Subject: Notice of Short Plat Application SP-20-00002 Colson

SUBJECT: Colson SP-19-00002

Subdivision Comments

Re: SP-20-00002

**COLSON SHORT PLAT
 PART OF SECTION 10, T. 17 N., R. 20 E., W.M.
 KITTITAS COUNTY, WASHINGTON**

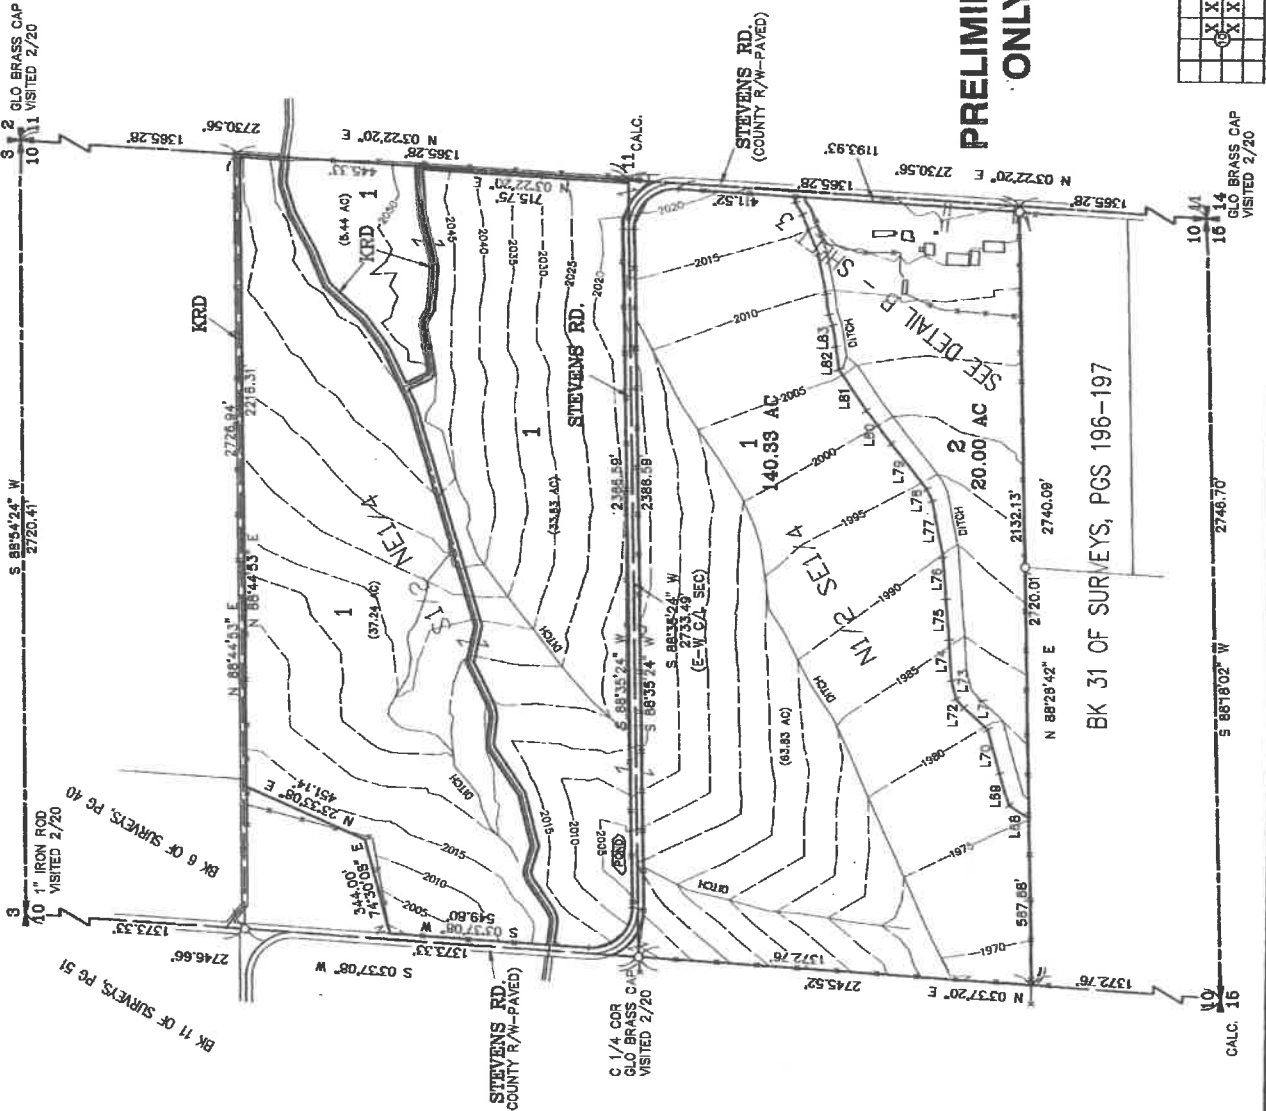
Need clarification on source of water, plat map indicates individual wells will be used, and the narrative indicates that the parcels will share a well. If the intention is to utilize a shared well, a signed, notarized, and filed shared well users agreement will also need to be provided before the short plat is finalized. The applicant must prove legal and physical availability of water for all new uses of water on proposed lots of this project, which can be provided through mitigation certificates (see **Condition B-1**) and a well log or 4 hour draw down test as proof of water adequacy for each new well (see **Condition B-2**). All persons who are making applications for land use including but not limited to short plats must comply with KCC Chapter 13.35.027 per KCC Chapter 13.35.020.

B-2 13.35.020(b) requires proof of adequate water supply, which can be submitted through a well log or 4 hour draw test result. If shared wells are used, a signed, notarized, and recorded shared well-users agreement must be submitted. All wells must meet the distance requirement of 50 feet from the property line, 50 feet from the septic tank and 100 feet from

COLSON SHORT PLAT
PART OF SECTION 10, T. 17 N., R. 20 E., W.M.
KITTITAS COUNTY, WASHINGTON

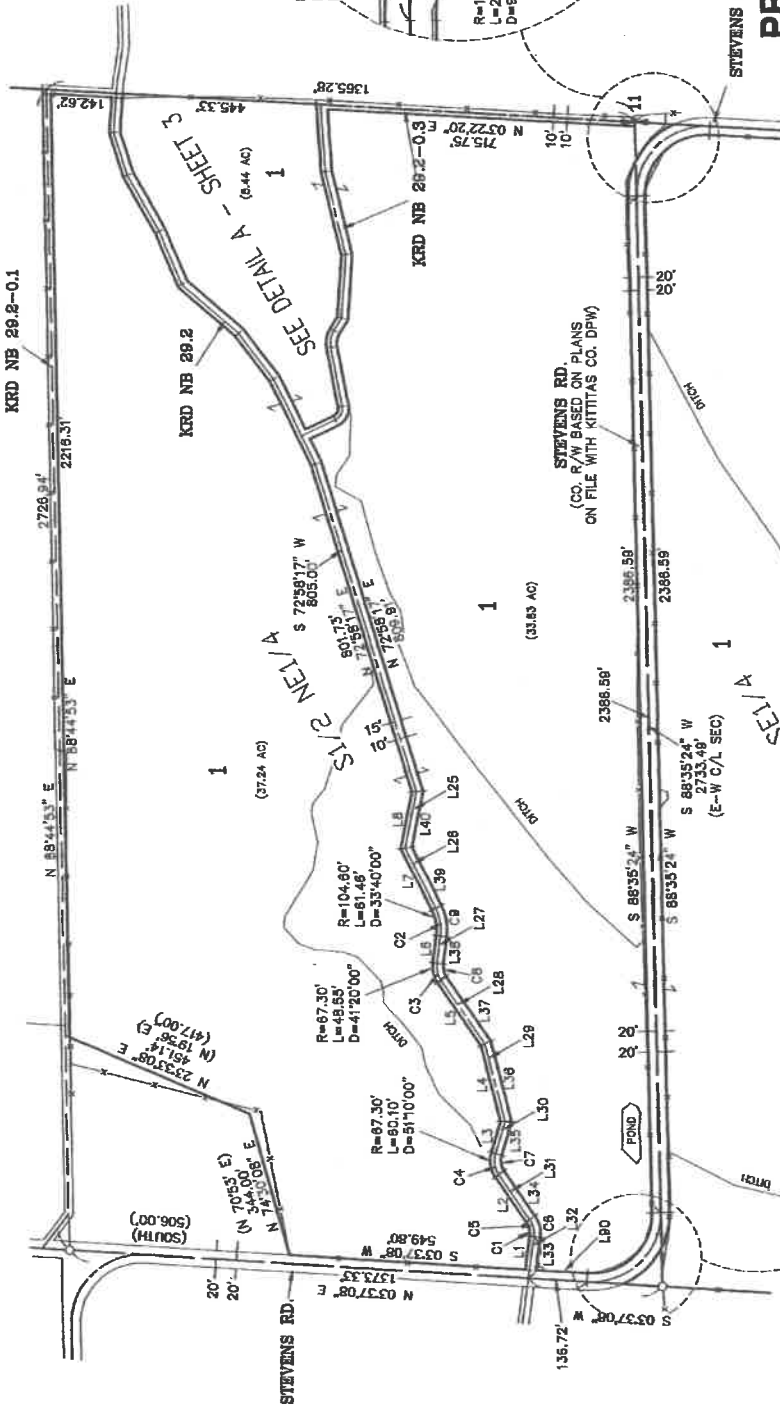
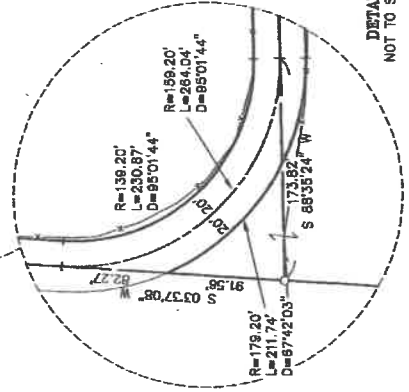
The division line between Lots 1 and 2 shall be staked in the field.
